SITE DEVELOPMENT PLAN, NEW CONSTRUCTION OF A BUILDING ON THE VACANT PORTION OF THE EXISTING LOT.

# CITY LINK TRUCKING

## 225 N. CURTIS RD. COLORADO SPRINGS, CO SITE DEVELOPMENT PLAN

PPR2339

DP-1

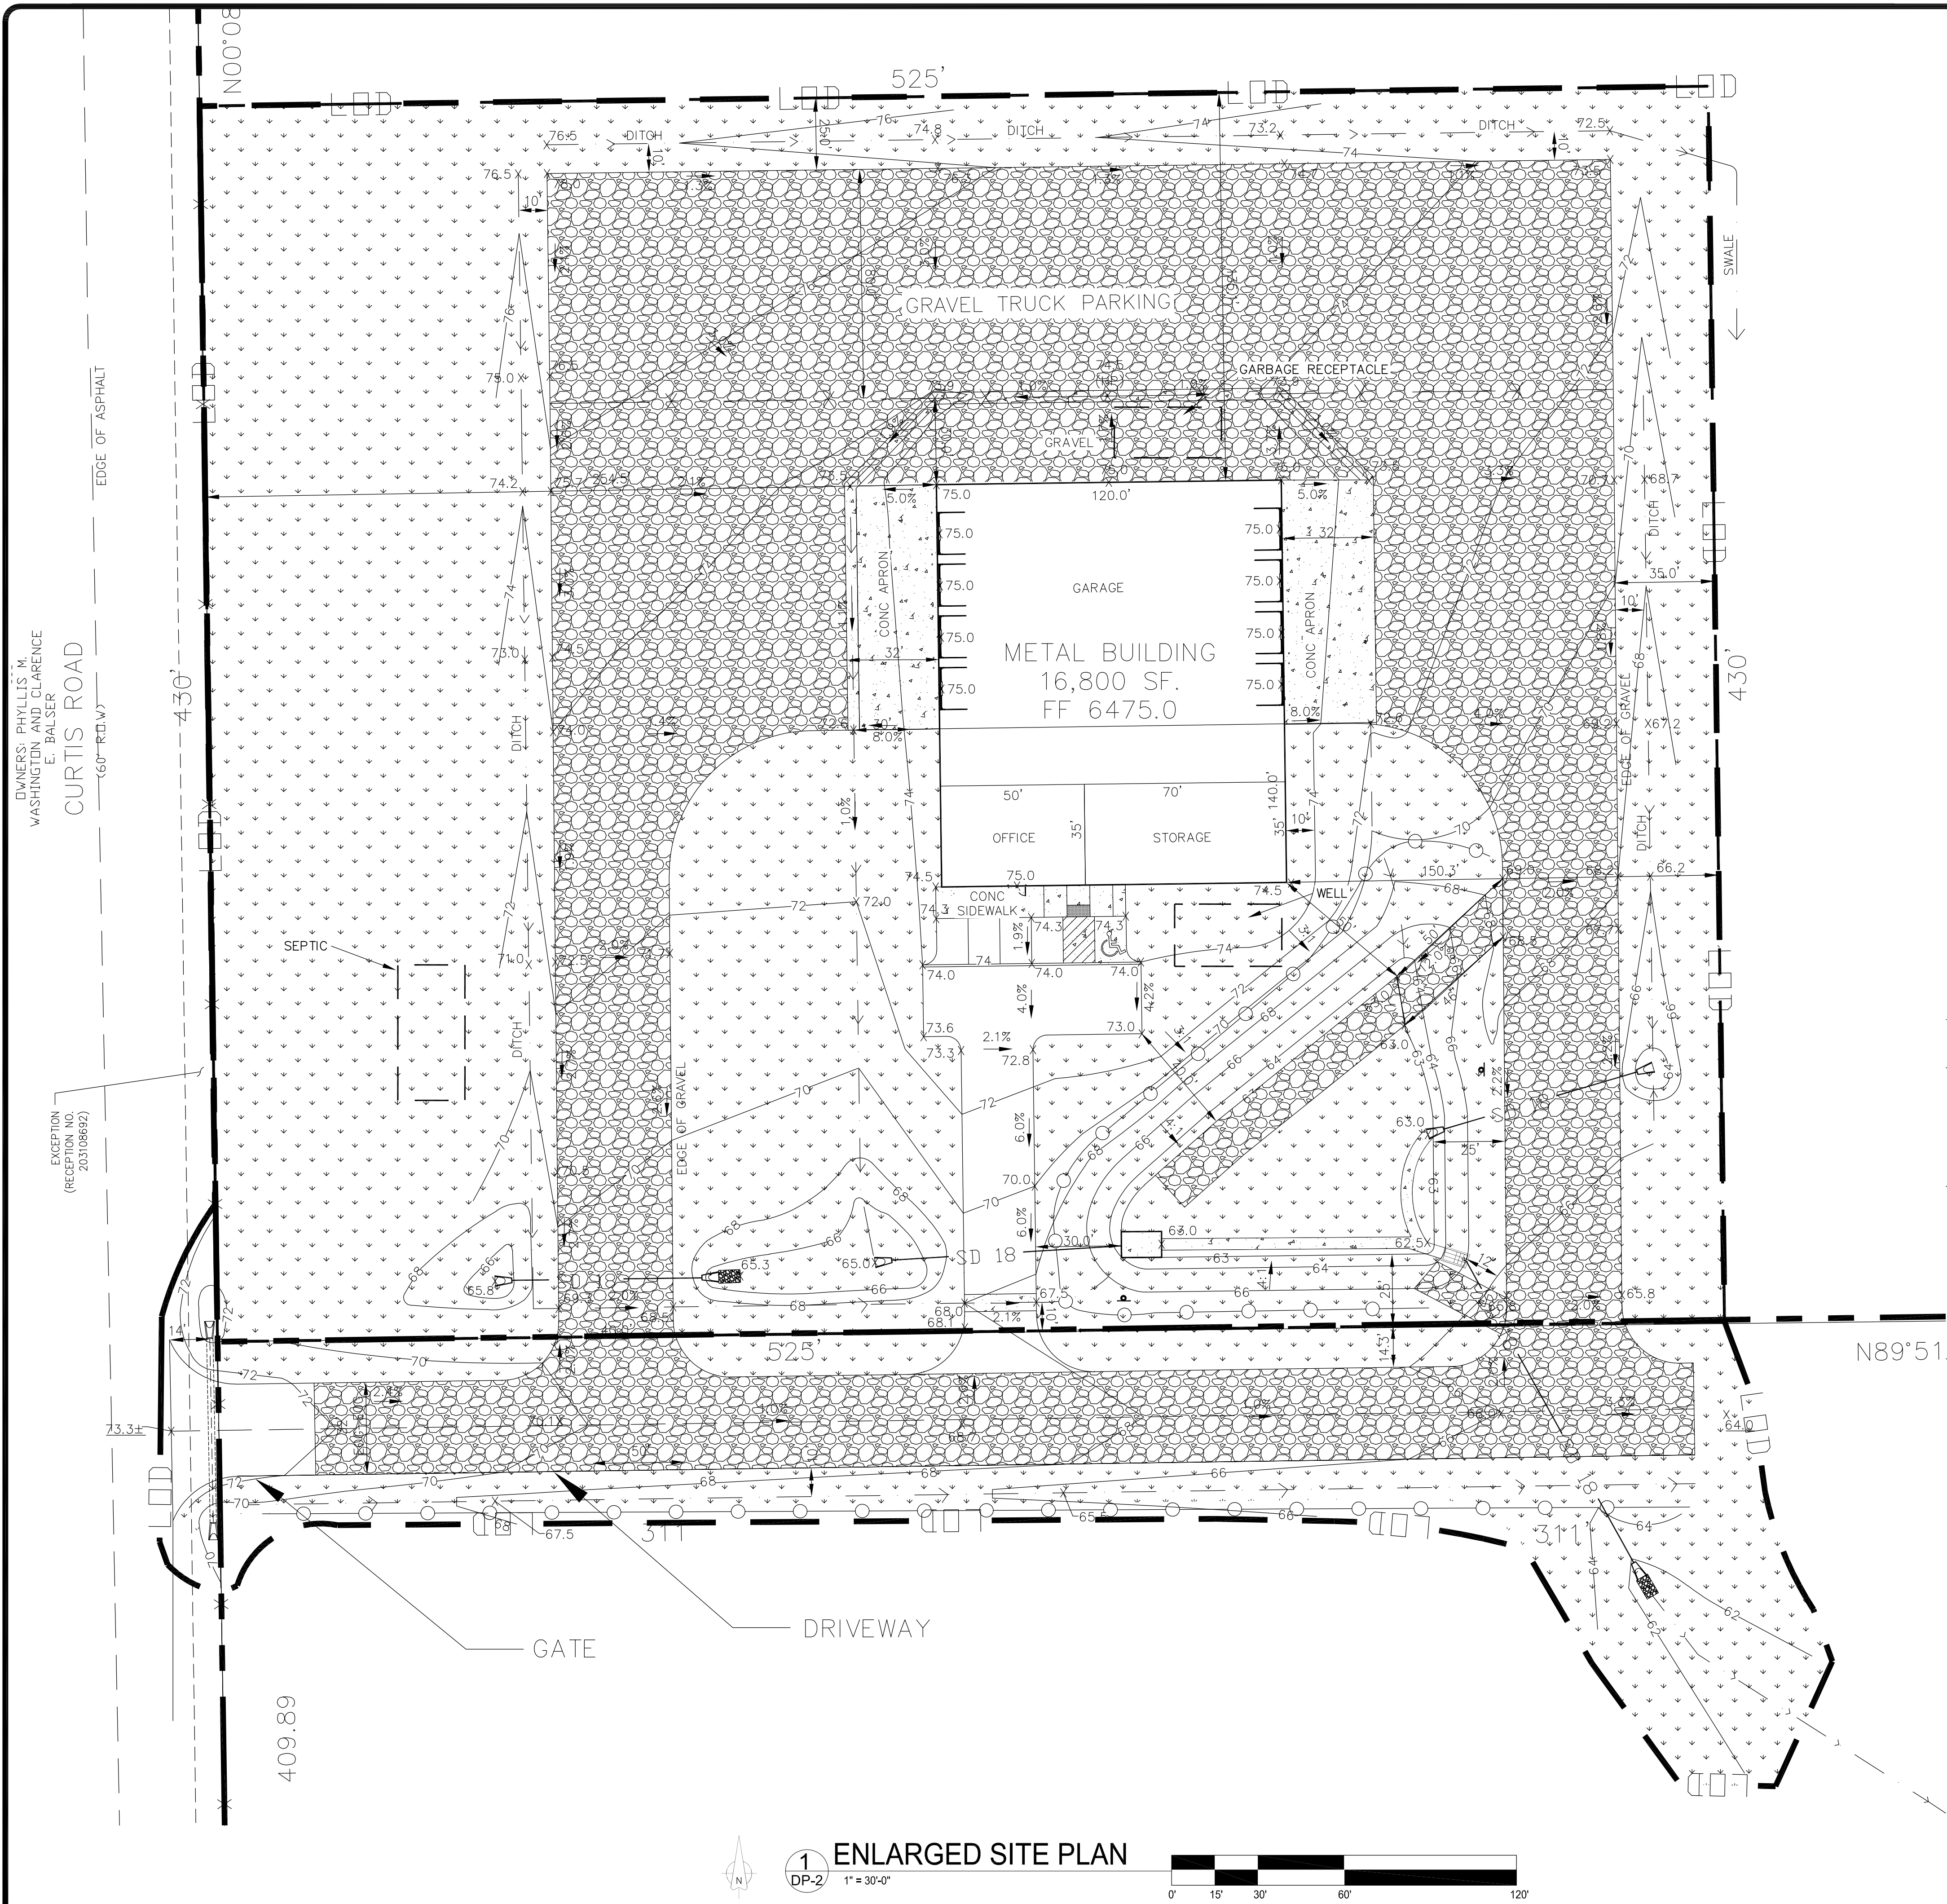
Vehicle storage = 3 spaces  
 Please update parking count to 9 spaces

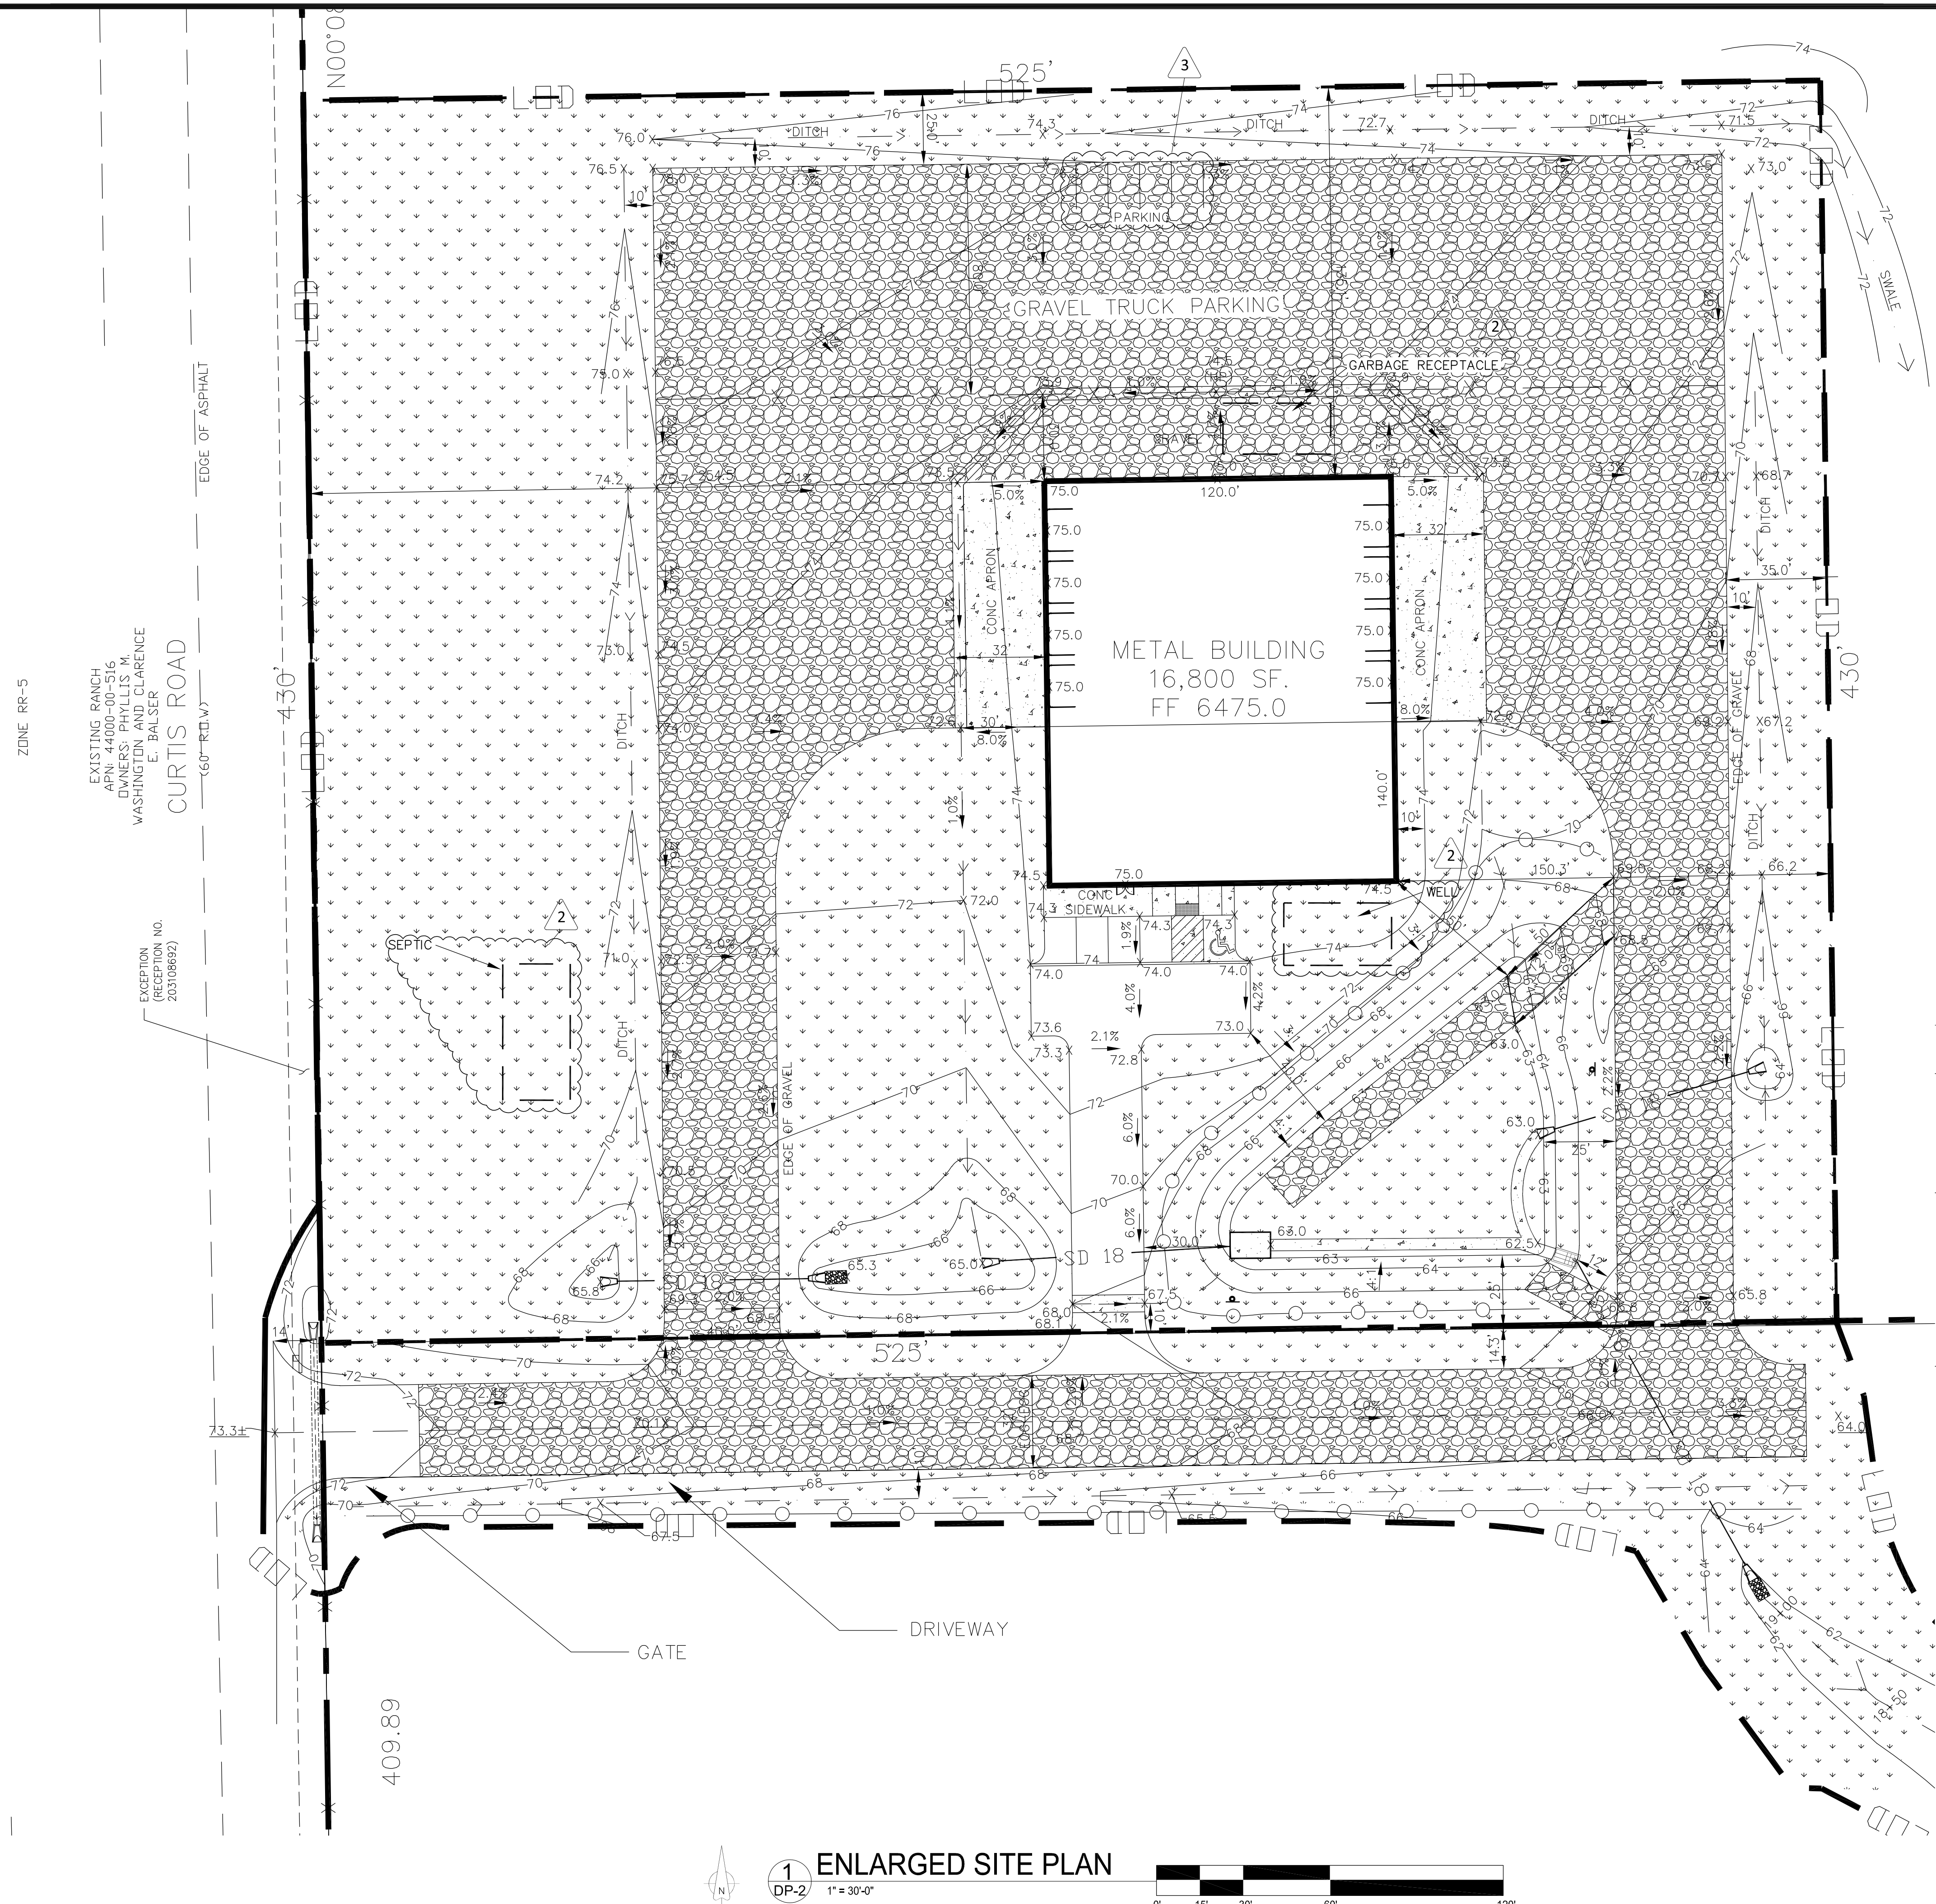
- screening mechanisms of garbage receptacles
- location of no build areas, floodplains or drainage ways (if none, then specify)
